Submissions Report No. 2  
New High School in Bungendore  
SSD-14394209

On behalf of  
NSW Department of Education  
November 2022

This Submissions Report has been prepared by Mecone Group Pty Limited on behalf of the NSW Department of Education to support the proposed new high school in Bungendore (SSD-14394209).

| Drawing Title | Proposed Site Plan - Gibraltar / Butmaroo Intersection 12.5 Bus as per Aust Roads Vehicle Circulation Swept Paths |

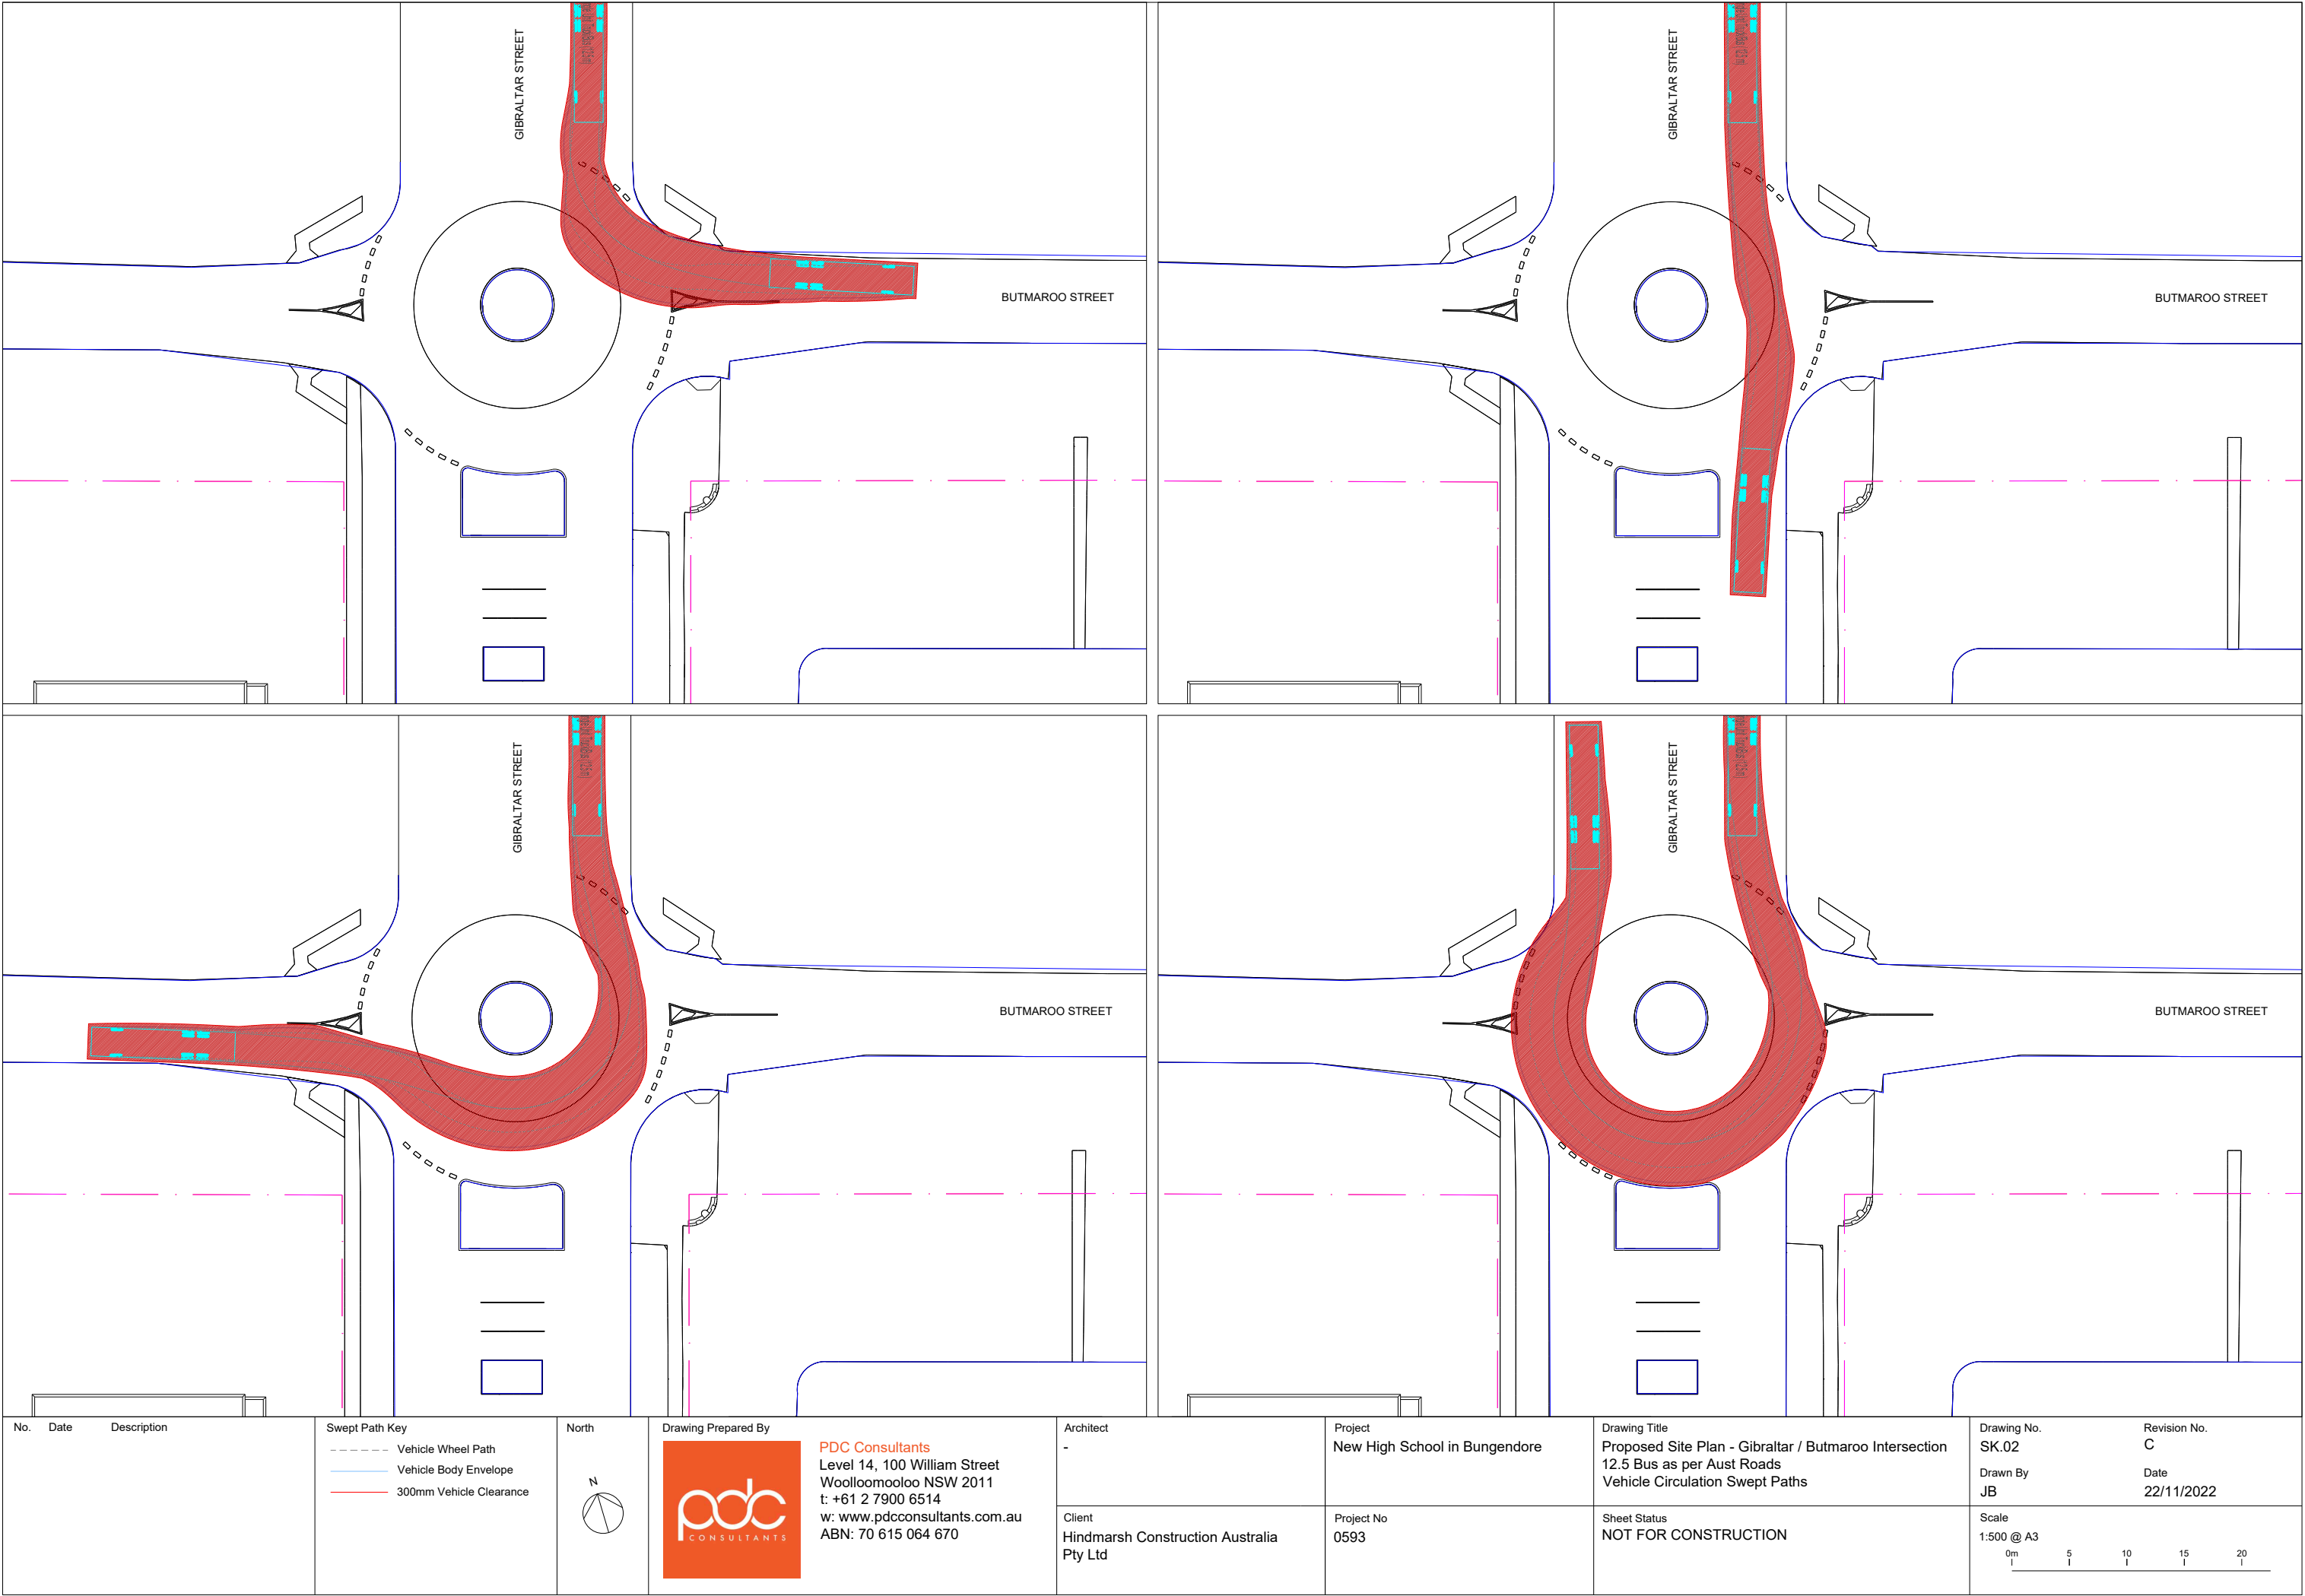
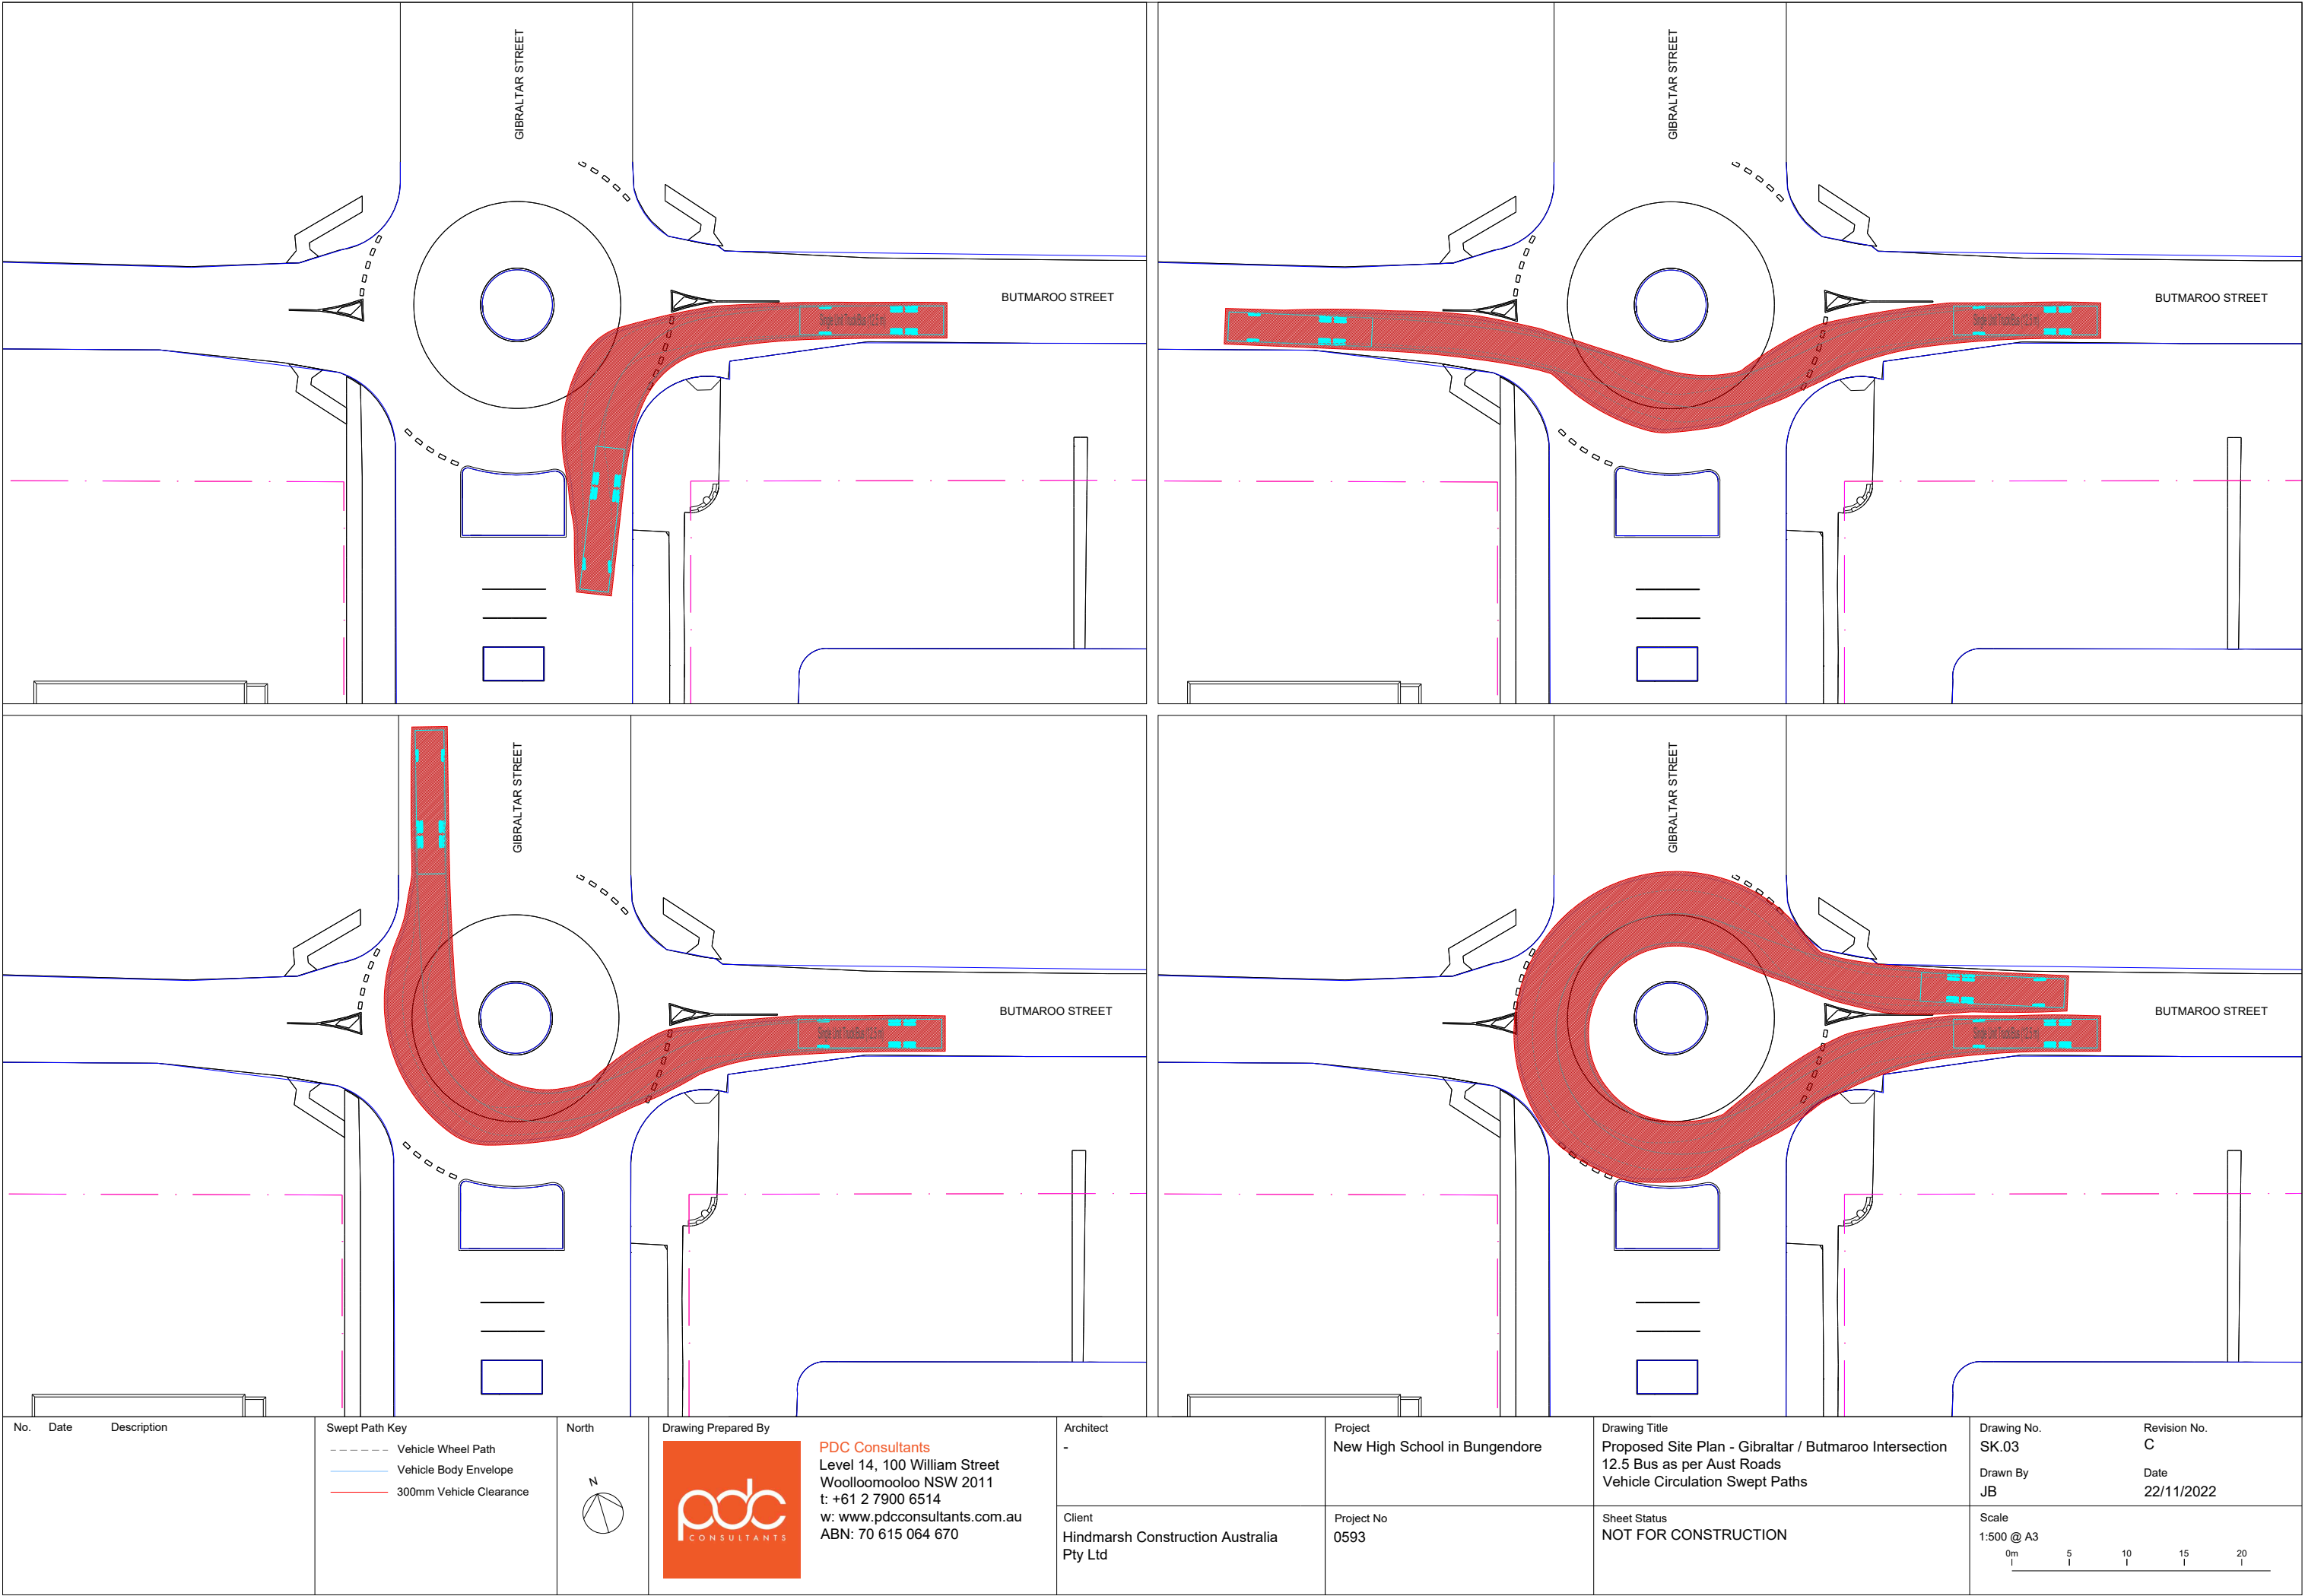
Council comment	Council recommendation	Response
by the frequent closure of Street due to flooding.		
<u>Roundabouts – manoeuvring:</u> Turning curves for a both 12 & 14 m buses need to be done at the Gibraltar/Majara Street and Gibraltar /Butmaroo roundabouts noting that this road is on our public transport route and adjacent to the train station. It isn't clear in the transport assessment addendum.	That the applicant provide engineered designs, noting any works to be carried out on verges adjacent to the proposed roundabouts on Gibraltar/Majara and Gibraltar/Butmaroo to facilitate turning movements for both 12 & 14 m buses, noting that these roads are on the public transport route and adjacent to the train station. It isn't clear in the transport assessment addendum. Note: During rail track works up to 3 full size coaches a day require to pull into the train station car park.	Kerb adjustments are required to facilitate the bus movements. The architectural, landscape and civil drawings have been updated accordingly ( <b>Appendix 3, 4 and 5</b> ). Swept paths are provided at <b>Appendix 9</b> .
